Application No: LU/214/20/PL

Site Address: Empty Supermarket Premises Avon Road Littlehampton BN17 6AT

Description of works: Demolition of existing buildings & redevelopment comprising 50 No. residential units (Class C3) & flexible commercial floorspace (Class A1, A2, A3 and/or D1) together with the provision of car & cycle parking, landscaping & associated works (resubmission following LU/3/19/PL). This application affects the setting of listed buildings & may affect the character & appearance of the East Street, Littlehampton Conservation Area. This application is in CIL Zone 4 (Zero Rated) as 'flats & other development'.

Thank you for your internet representation made on 2nd September 2020 which has been recorded as an objection with the comments as follows:

Proposed elevation on East Street

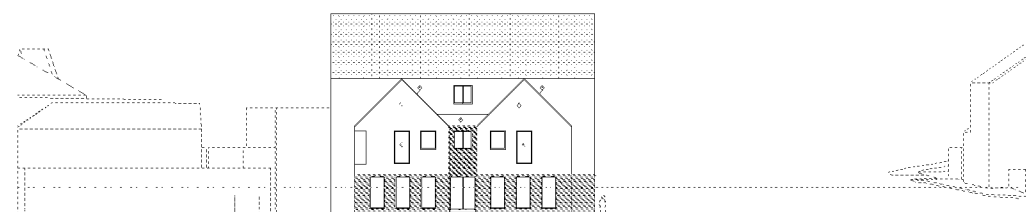
(2) The block fronting East Street and the conservation area appears out of keeping in its configuration, massing, form, and fenestration treatment with the historical and good quality townscape context, which includes several Listed Buildings
